Our Ref: TR010022

Date: 21 May 2019

### **Application by Highways England for an Order Granting Development Consent for the A38 Derby Junctions Improvement.**

#### **Advice following issue of decision to accept the application for examination**

Drawing Title
**LAND PLANS
REGULATION 5(2)(i)
KEY PLAN**

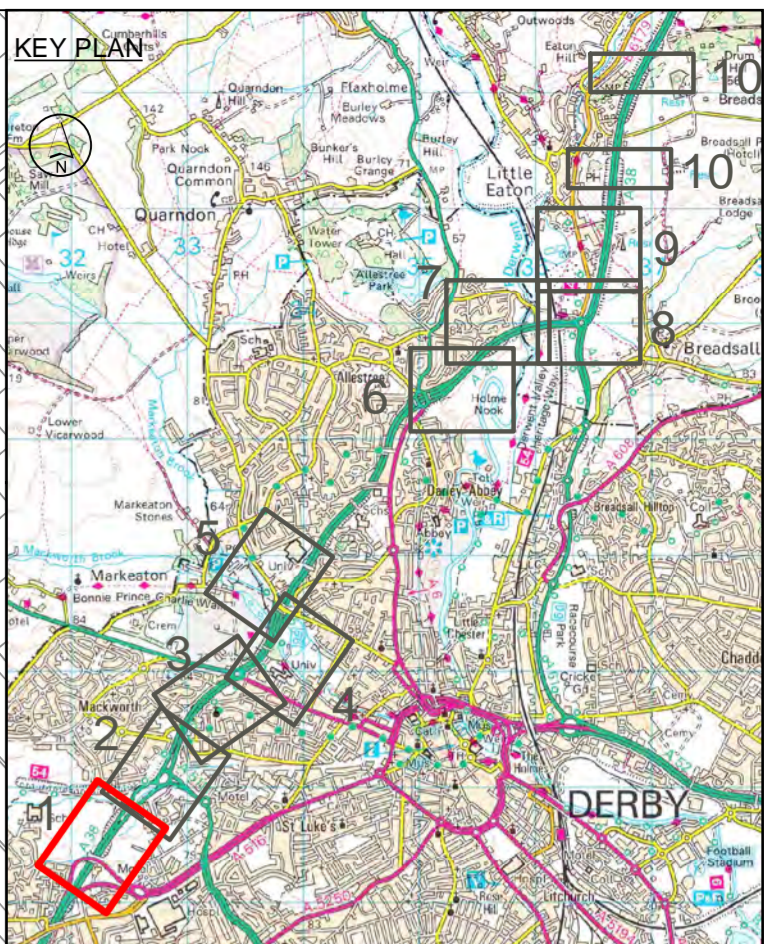
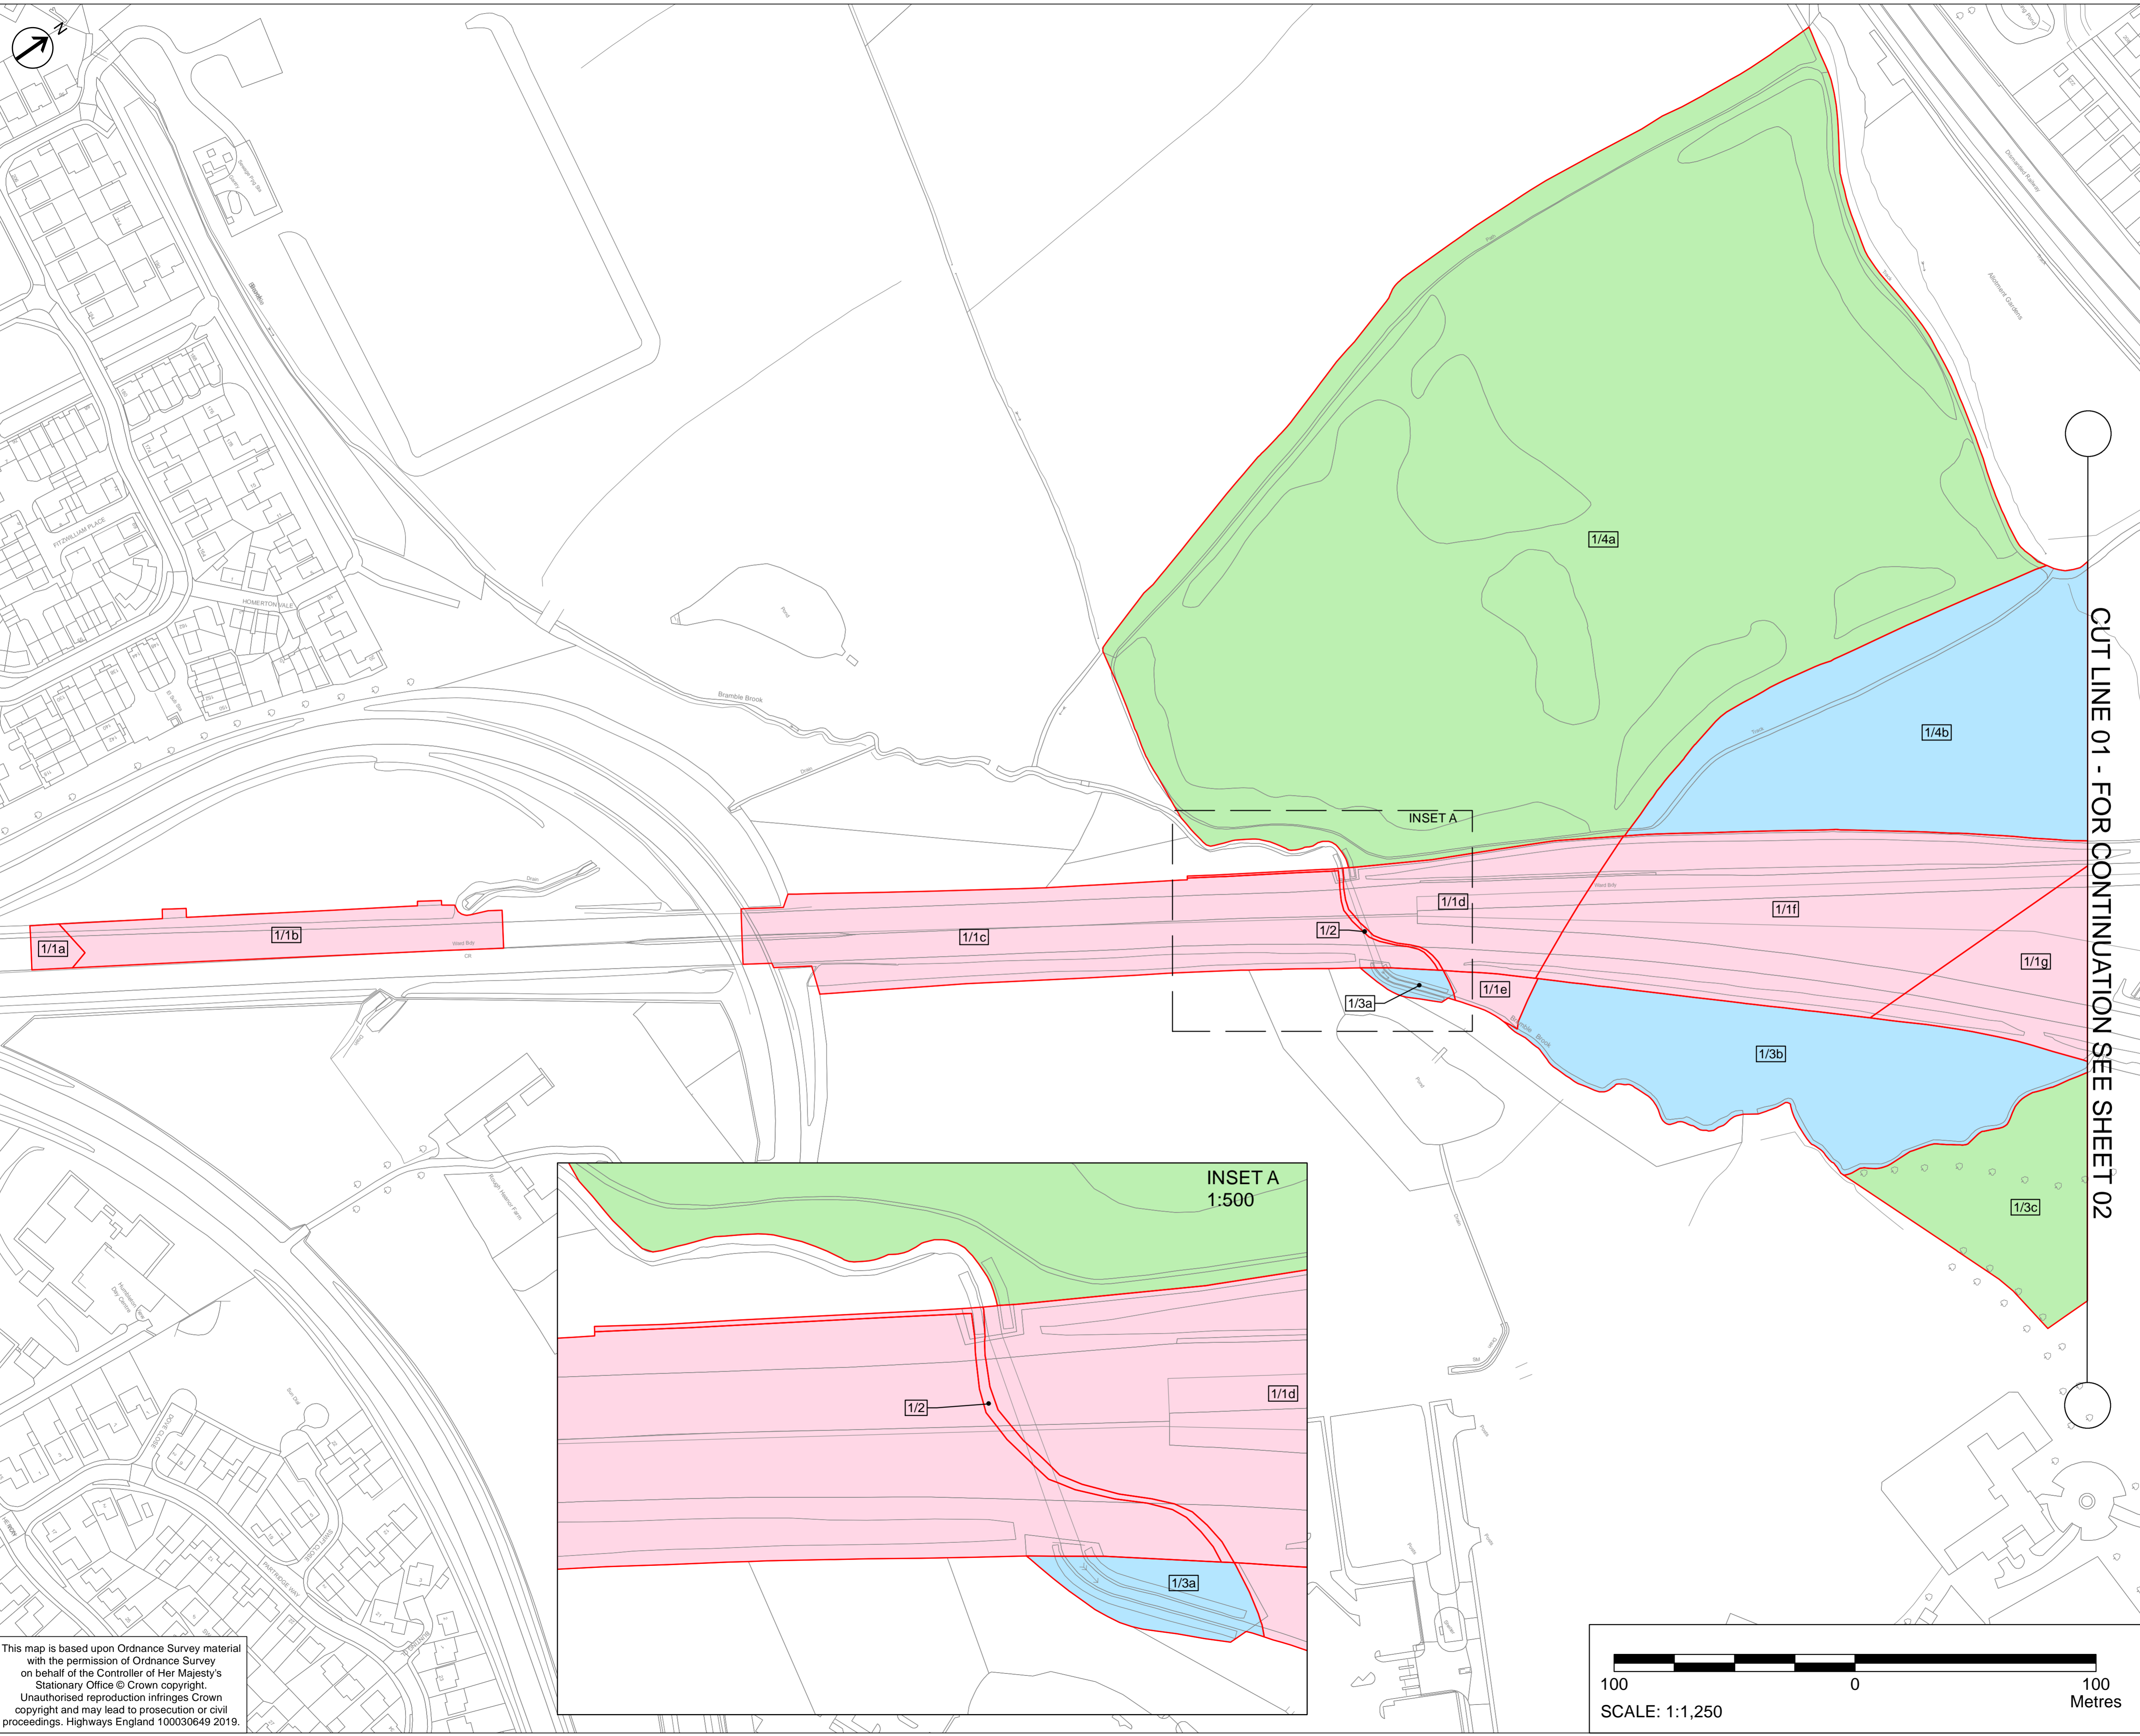
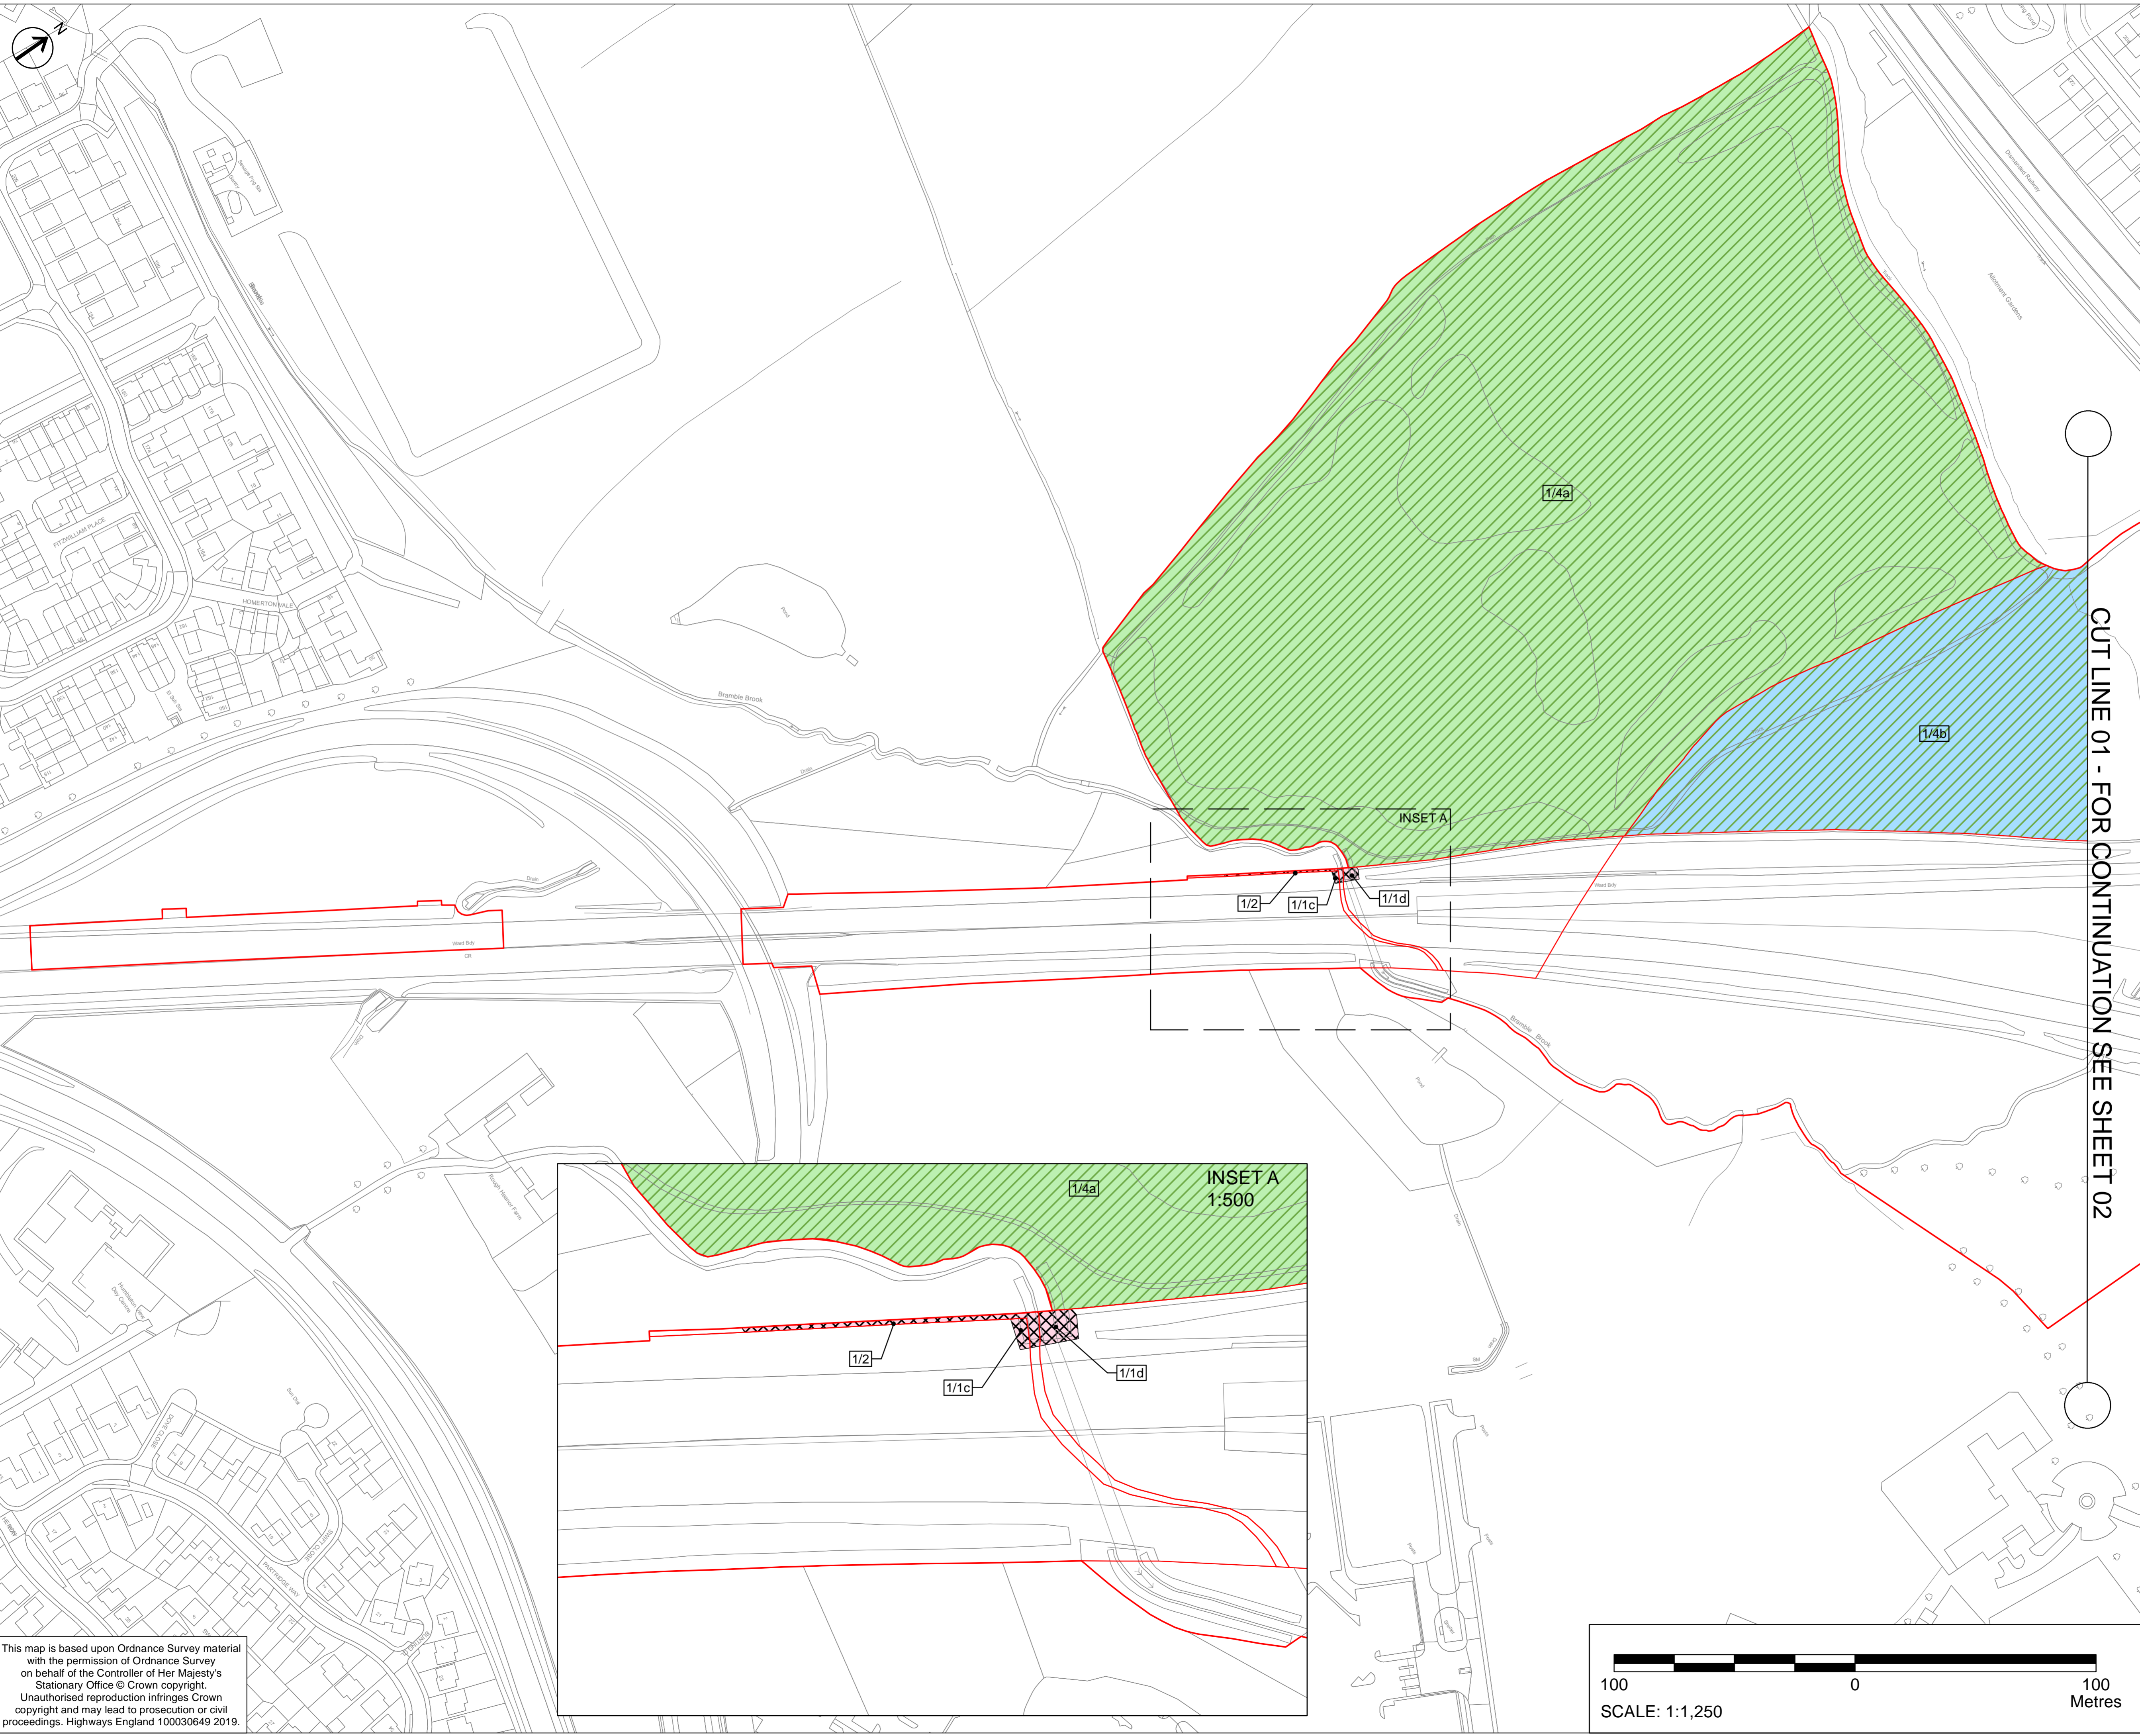
The Applicant is advised to review these plans, and particularly the Special Category Plans, for consistency with the book of reference, having particular regard to whether or not land is to be used temporarily or acquired permanently.
